SM Rocha, LLC response to review comments 10/27/22

MASTER TRAFFIC IMPACT STUDY

**Flying Horse North
El Paso County, Colorado
PCD File No. SKP223**

PLAN

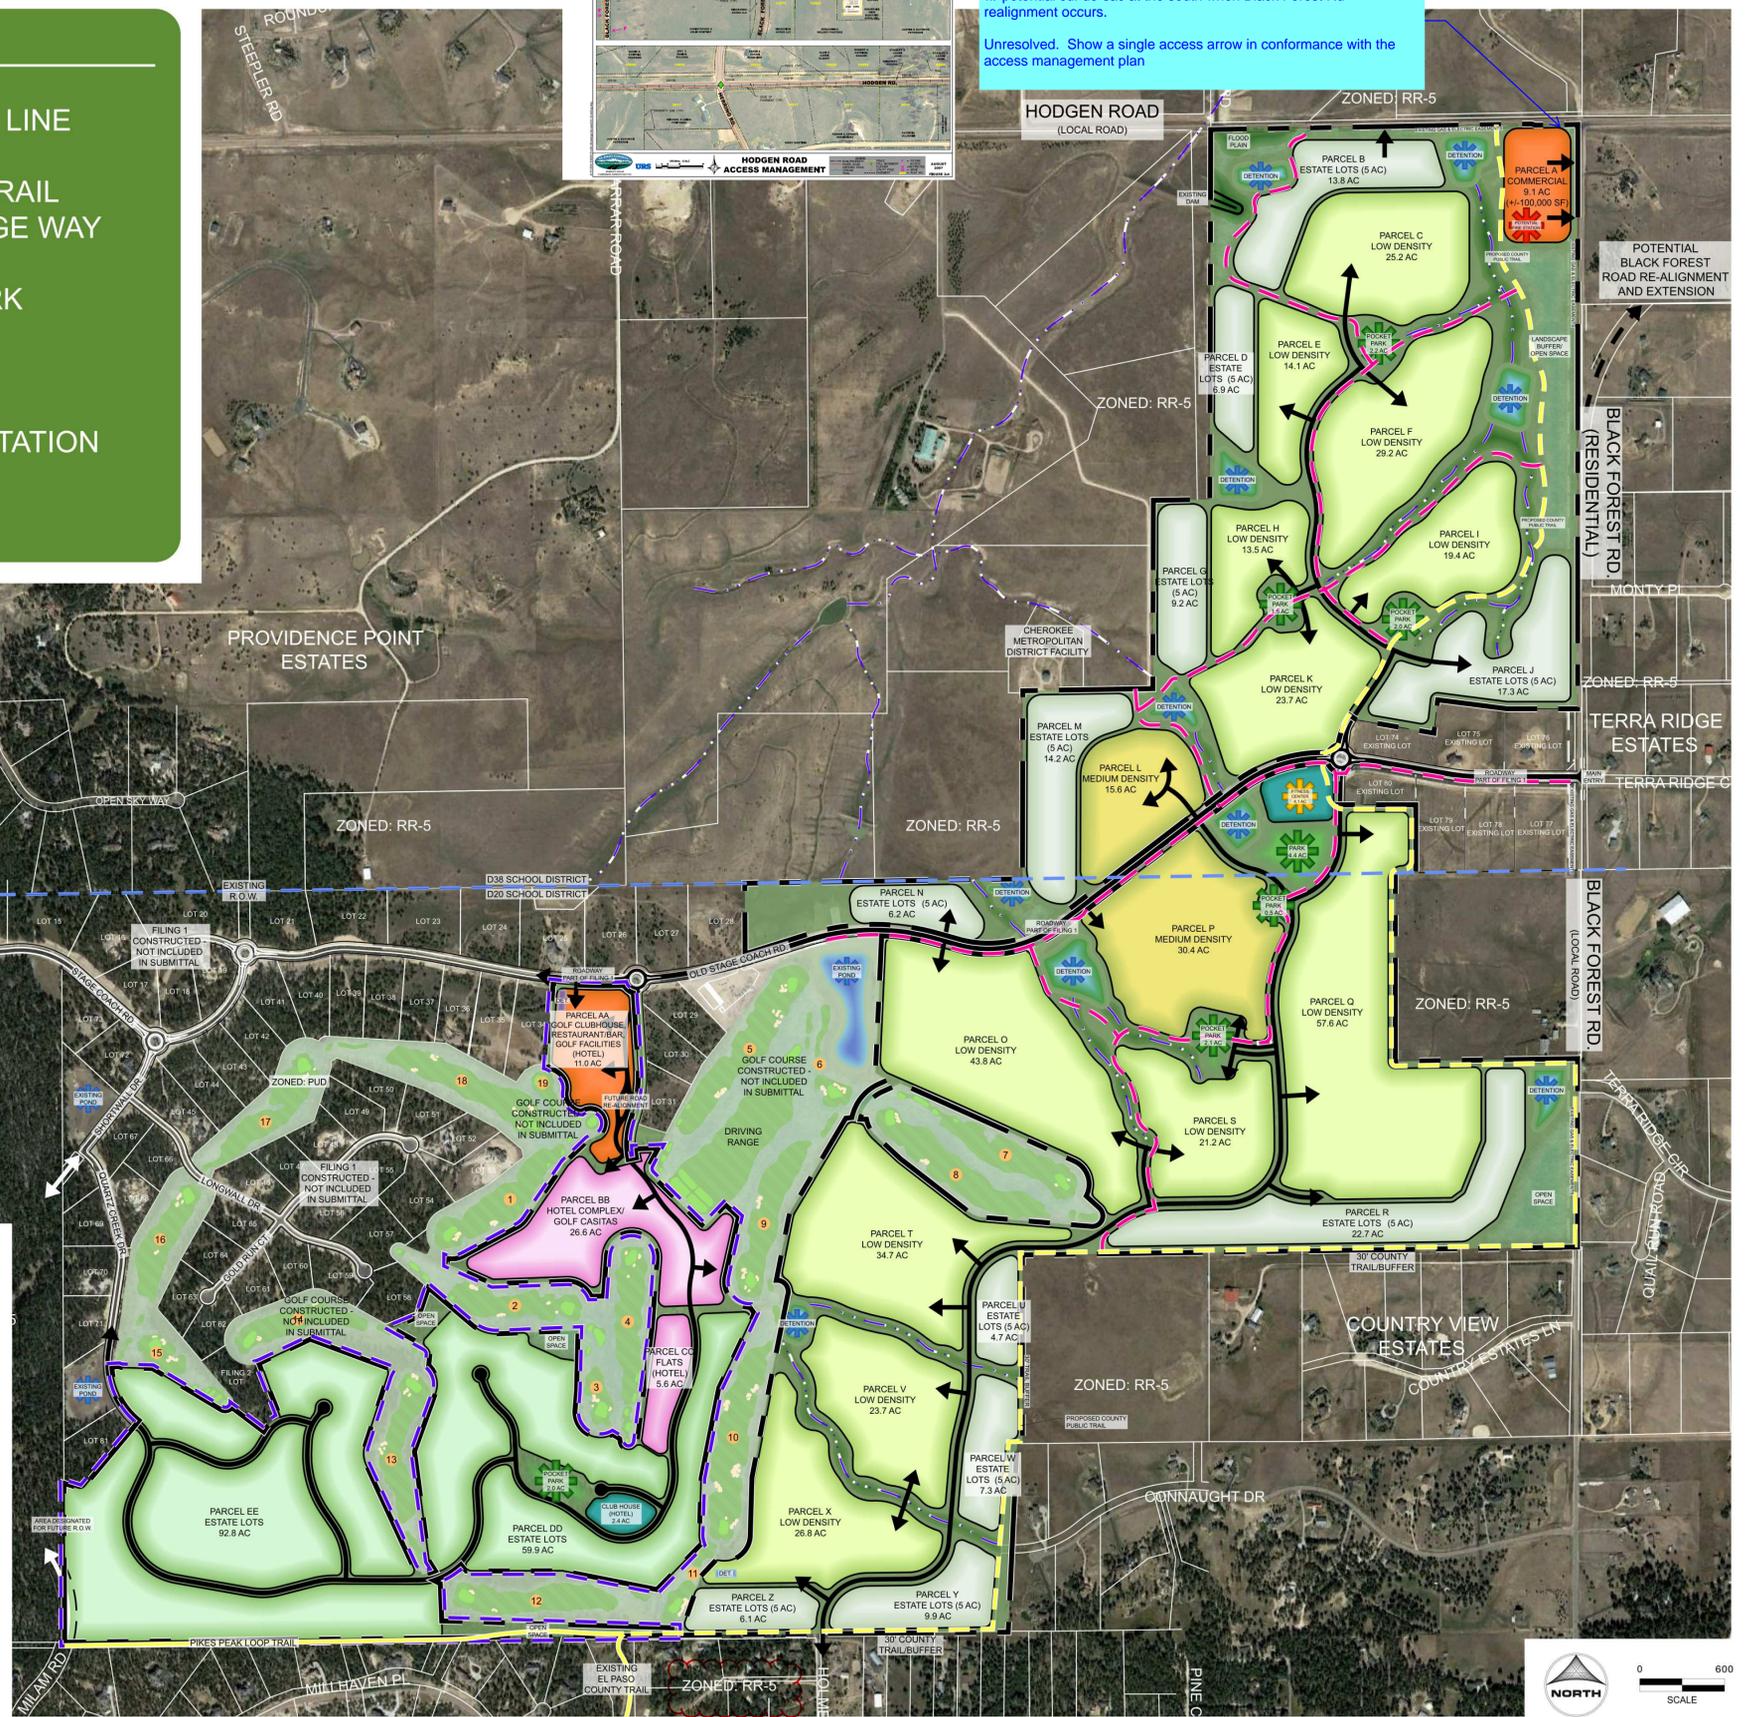
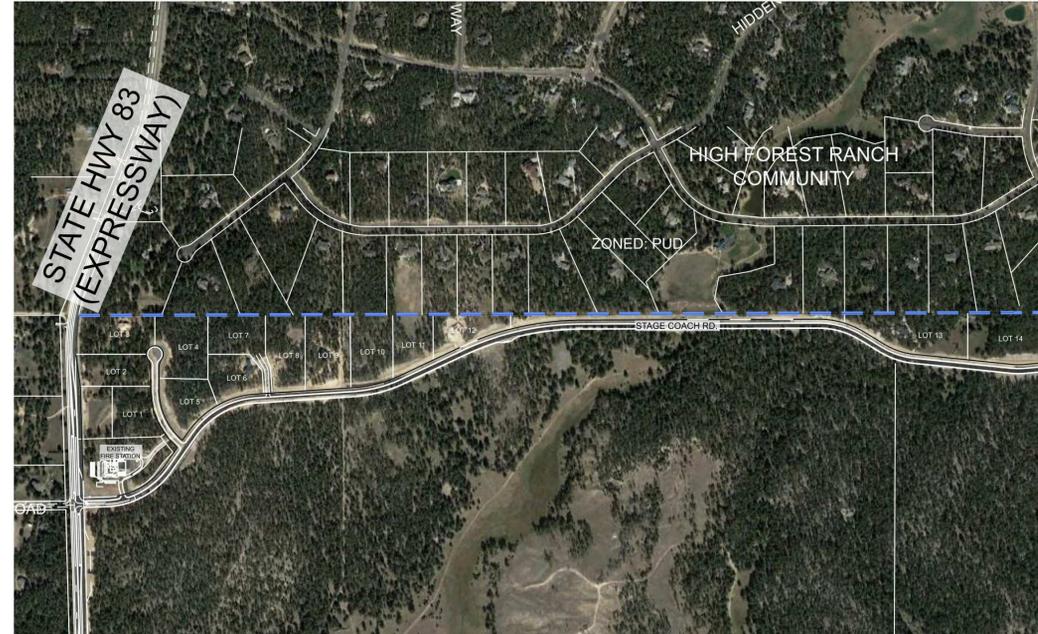
Review and include the Hodgen Road Access Management Plan and Corridor Preservation Plan

Unresolved. Update the reference. Staff has upload the El Paso County Hodgen Road AMP (Aug 2007), as a separate comment on eDARP. The AMP does not show access along the development frontage to Hodgen Rd.

Provide a statement that the applicant is anticipated to submit a deviation request for any proposed access to Hodgen with subsequent subdivision application.

Comments acknowledged.
